**Consultation Response from Chris Bembridge KC,
Highways Development Management**

2021/93305 61-65, New Street, Huddersfield, HD1 2BQ

Change of use and conversion of existing buildings, forming split-level six storey development comprising four-storey stairwell, four-storey roof-top tower block and enclosed courtyard to create 25 dwellings and sub-division of the retail unit forming 61-63 New Street (Full Application)

Date Responded: 19/06/23

**PROPOSED BASEMENT FLOOR GENERAL ARRANGEMENT PLAN**

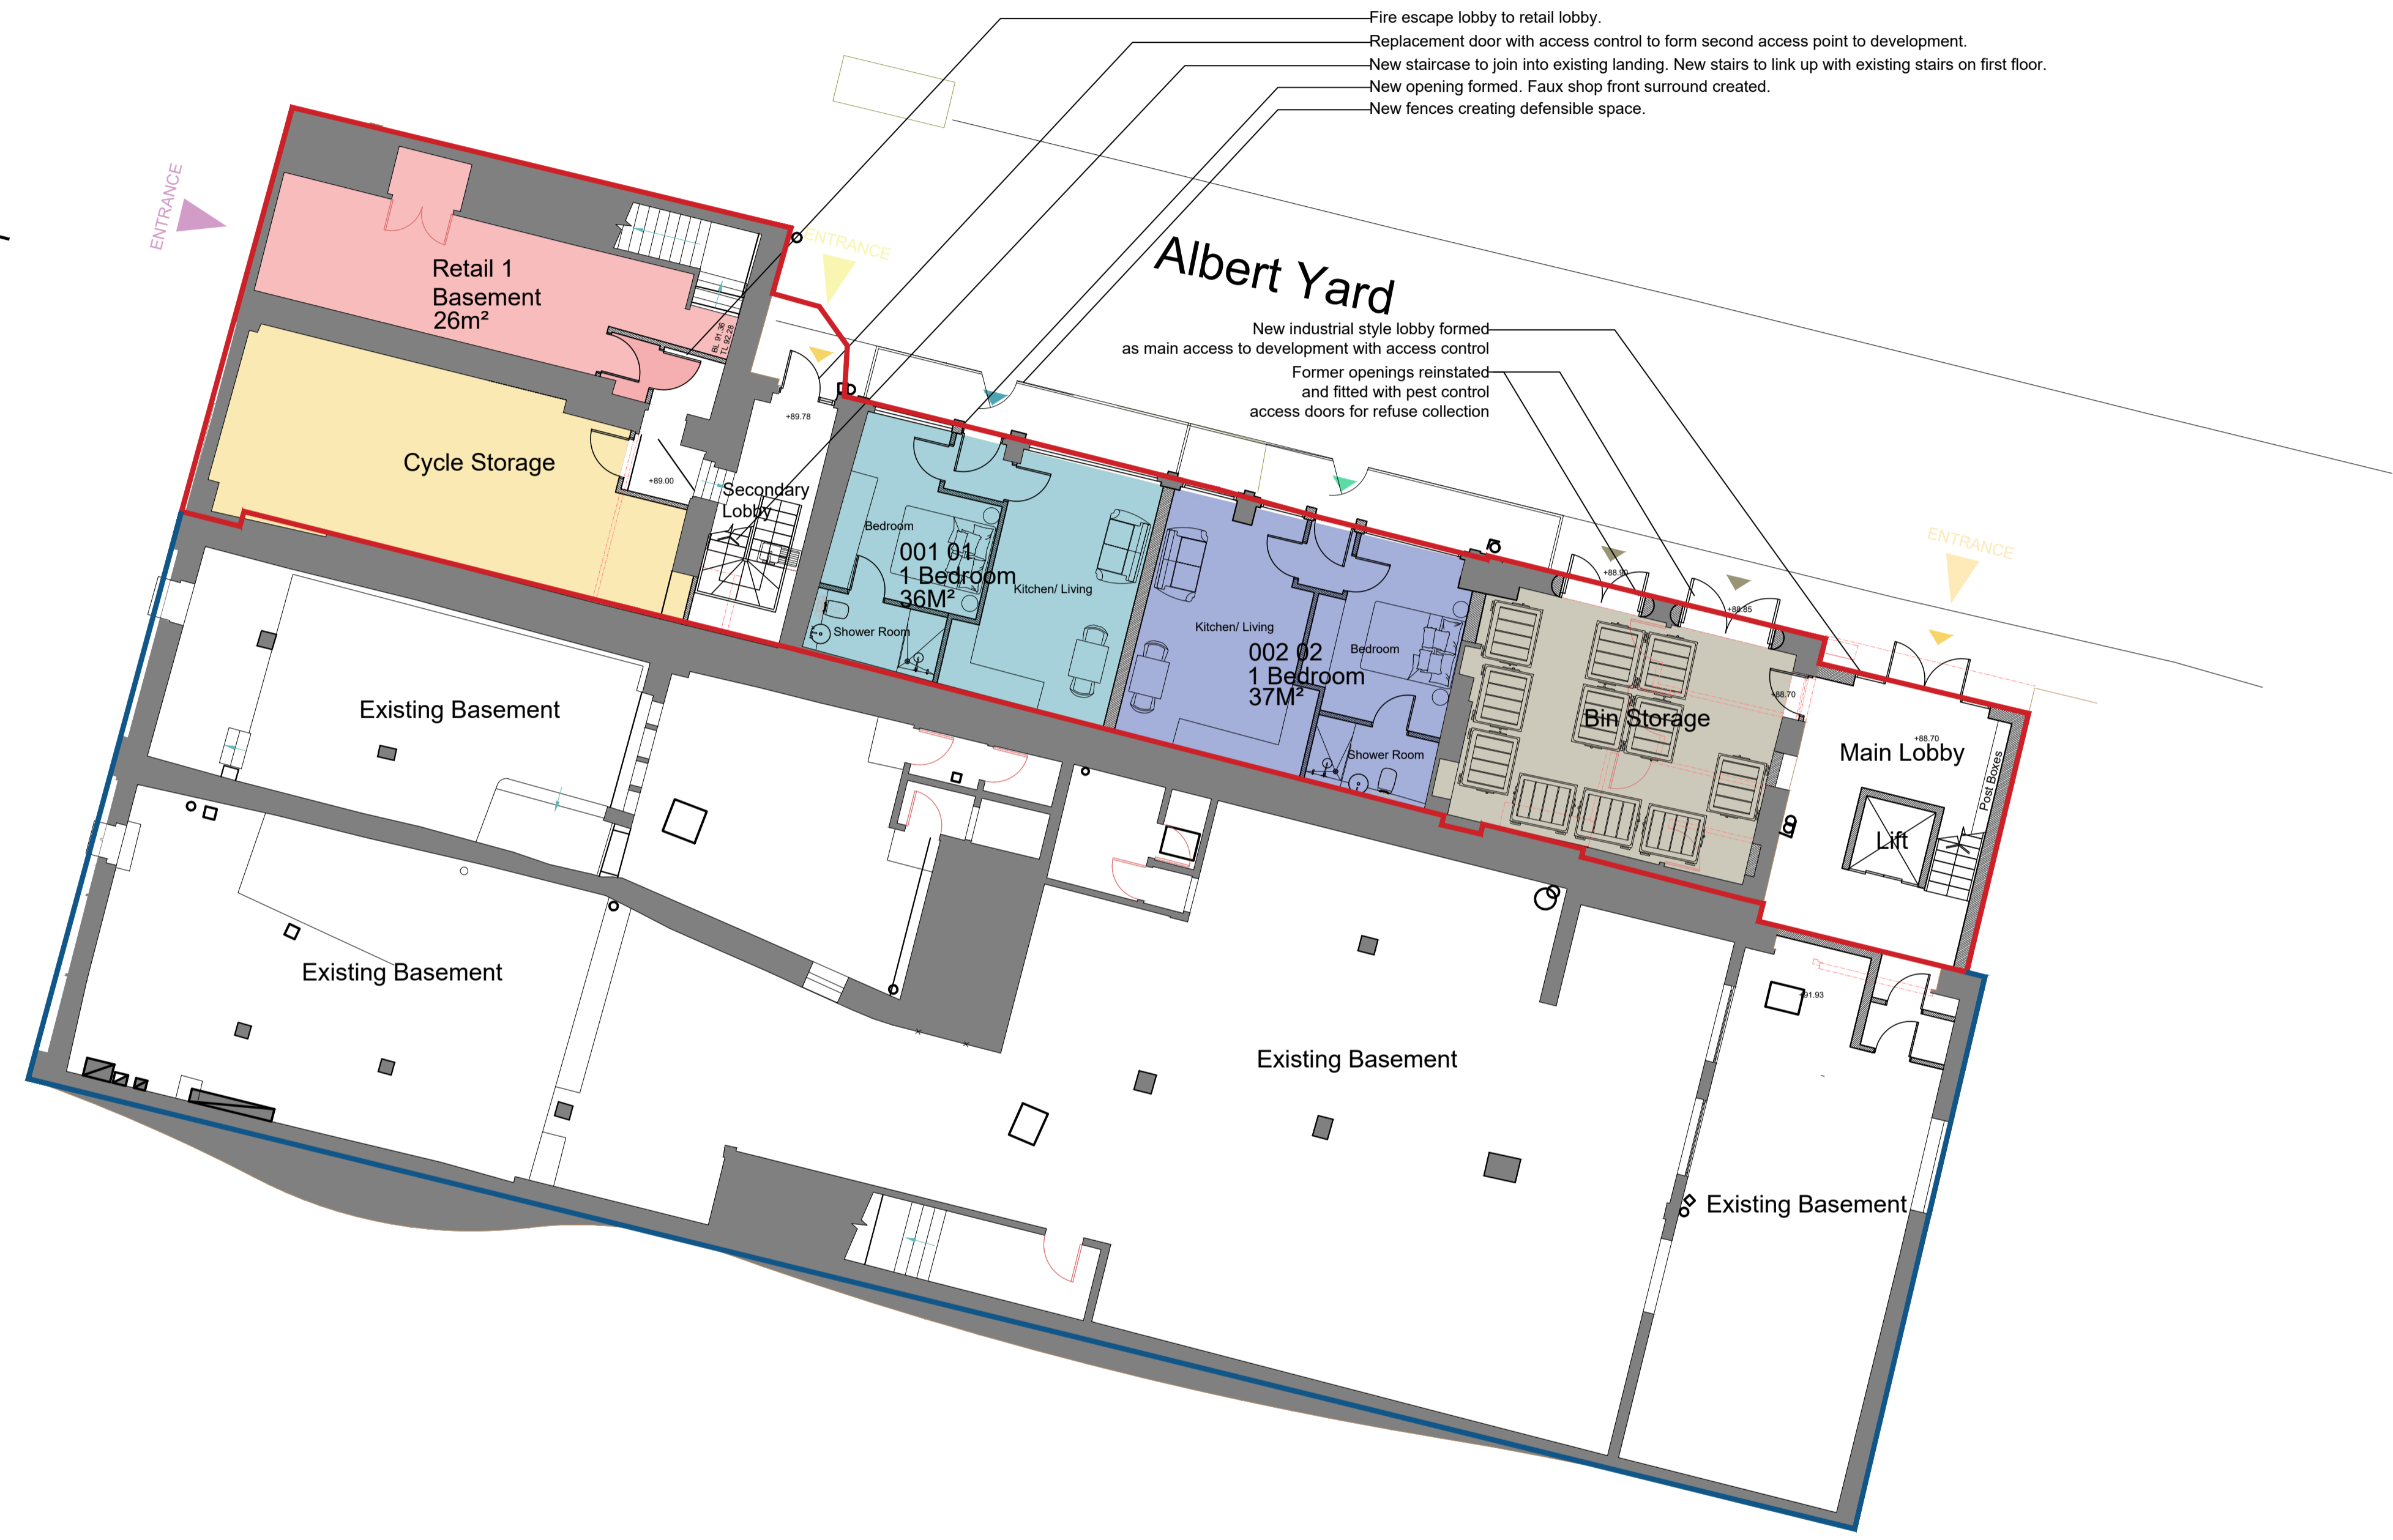
Drawing No (100)10 Rev D shows a room within the basement for cycle storage, however no details of racking were provided. The room is approximately 4m x 10m and we would like to see detail of how this will provide safe and secure storage for up to 31 cycles. Also we would like to see how the routes from ground level to the room will be provided with cycle facilities to allow cycles to be easily manoeuvred up and down any stairs along the route, this may include the installation of cycle gutters along the stairs. Details of how security to the room will be arranged should also be provided. This can be conditioned.

Waste storage is shown within the basement level and would be accessed via Albert Yard and Victoria Lane. Street view shows a number of waste bins awaiting collection and so it is assumed that access along Victoria Lane is achievable by a refuse vehicle, however we would recommend that the exact details of refuse collection is agreed with the Kirklees waste strategy team at the earliest opportunity.

Before development commences details of safe and secure storage and access for cycles should be submitted to and approved in writing by the Local Planning Authority. The approved details shall be provided before first occupation and shall be so retained thereafter for the lifetime of the development.
